Design Review Panel Meeting 20 - Minutes

Meeting Number: Meeting 20 - 2016

Date: 22 February 2016

3.2	The DRP has no comments but is interested in the progress of the Kengo Kuma design	
3	South East Plot	
3.1	Richard Francis-Jones presented the design of the South East plot • The building consists of Podium with three residential towers ○ SE1 is the main tower ○ SE2 comes from ground level to above the podium on the North West corner ○ SE3 is slightly above the podium on Harbour Street. • The building fits within the Parameter plan. • The materials and character of Paddy Markets and Ultimo • 391 Apartments and 270 parking spaces • Hay Street façade is developed with a colonnade due to of stormwater culverts and the required clearances. • Hay Street has entrance lobbies to the SE1 tower. Parts of the wall are solid due to support of the core of the tower. This results in a long internal corridor to the lift core.

02 SECTION Podium North South - Retail 02 to SE1 and SE3 Foyer
1:200

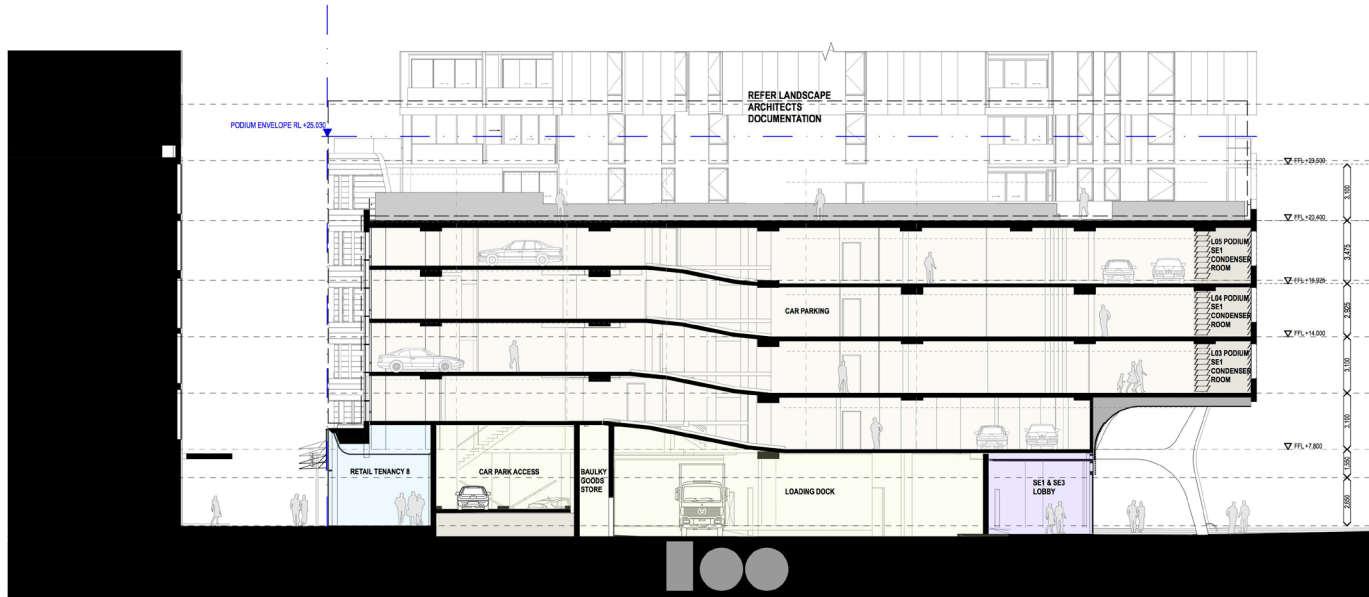
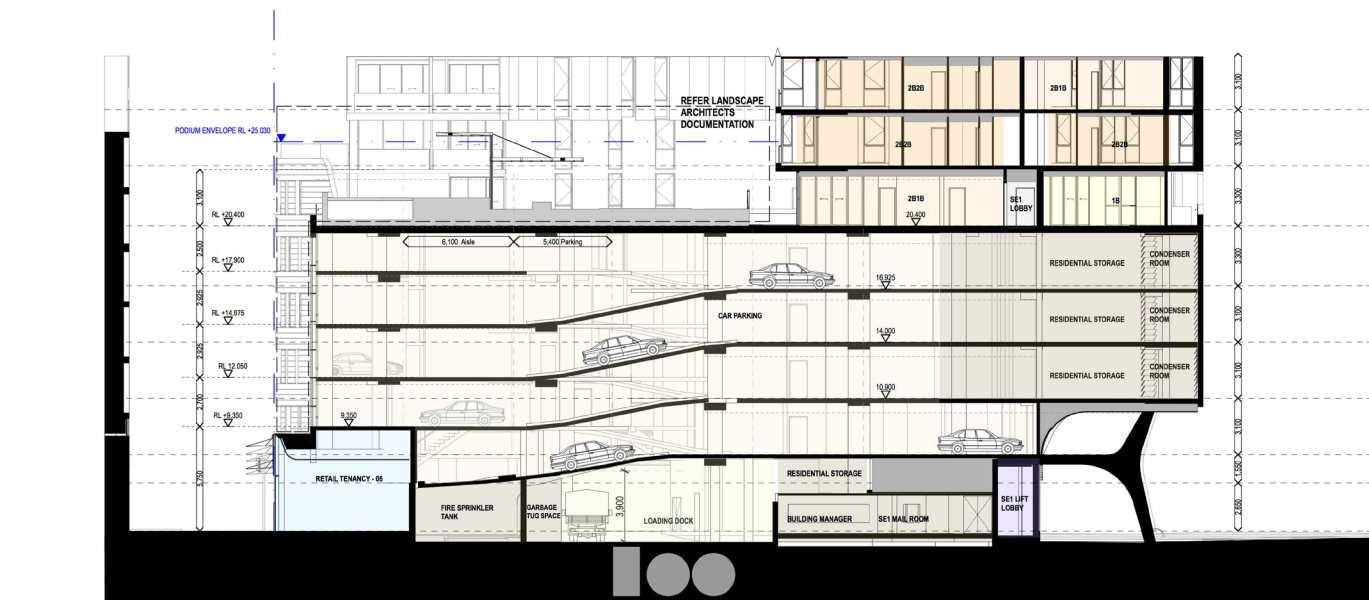
3.2	DRP commented upon • the need for activation/oversight of the area under the colonnade on Hay street to avoid squatters/the homeless camping there. • the lobby /foyer area of SE1 needs special design attention to remove the long internal corridor effect.
